From: [Nina Wilson](#)
To: [West Burton C](#)
Subject: West Burton C - Written Questions & Request for Information (Ref: 20022801) - Ecology Comments
Date: 06 December 2019 10:08:01

In relation to question 3.12:

**Figure NTS10: landscaping and biodiversity management and enhancement areas**

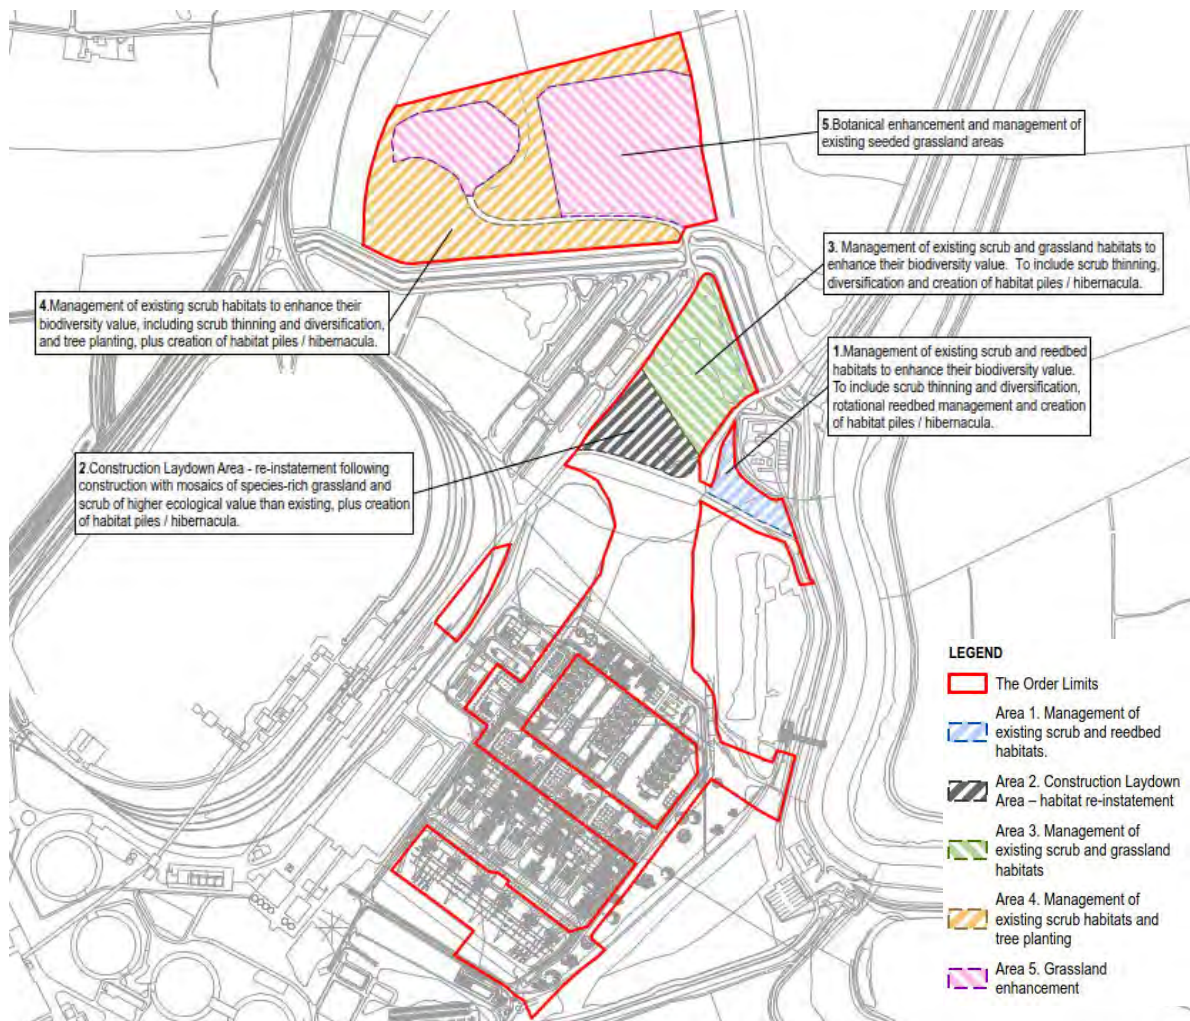
The applicant proposes to enhance the ecological value of an area identified at Bole Ings, to compensate for the net loss of habitat arising from the proposed scheme. They will use the Defra offsetting metric with the aim of demonstrating an uplift in value of the Bole Ings area arising from their enhancement works, sufficient to deliver no net loss of biodiversity. However, the area in question was previously enhanced as a requirement of another planning application at the site, and is, ostensibly, already an area of species-rich grassland - although there are no surveys available to demonstrate the current status of this area, and the offsetting metric calculation has not yet been carried out. The pertinent issues are that:

- The area in question at Bole Ings should already have been restored to species-rich grassland
- If the area is not already species-rich grassland, then this suggests that the requirements of the aforementioned planning permission were not properly implemented
- If the area is species-rich grassland, then the potential to further increase the value of this area will be limited.

If the latter is true, then it is not certain that the necessary level of uplift in ecological value will be achieved, which is where the suggestion came from that additional land may be required. This is also why in the SoCC it is recognised that the Defra offsetting metric and LBMEP provide an appropriate *framework*, but that an agreement on all details of proposed enhancements within the Bole Round area remains to be agreed. In short, there is a risk that the necessary level of ecological compensation cannot be achieved within the Bole Ings area.
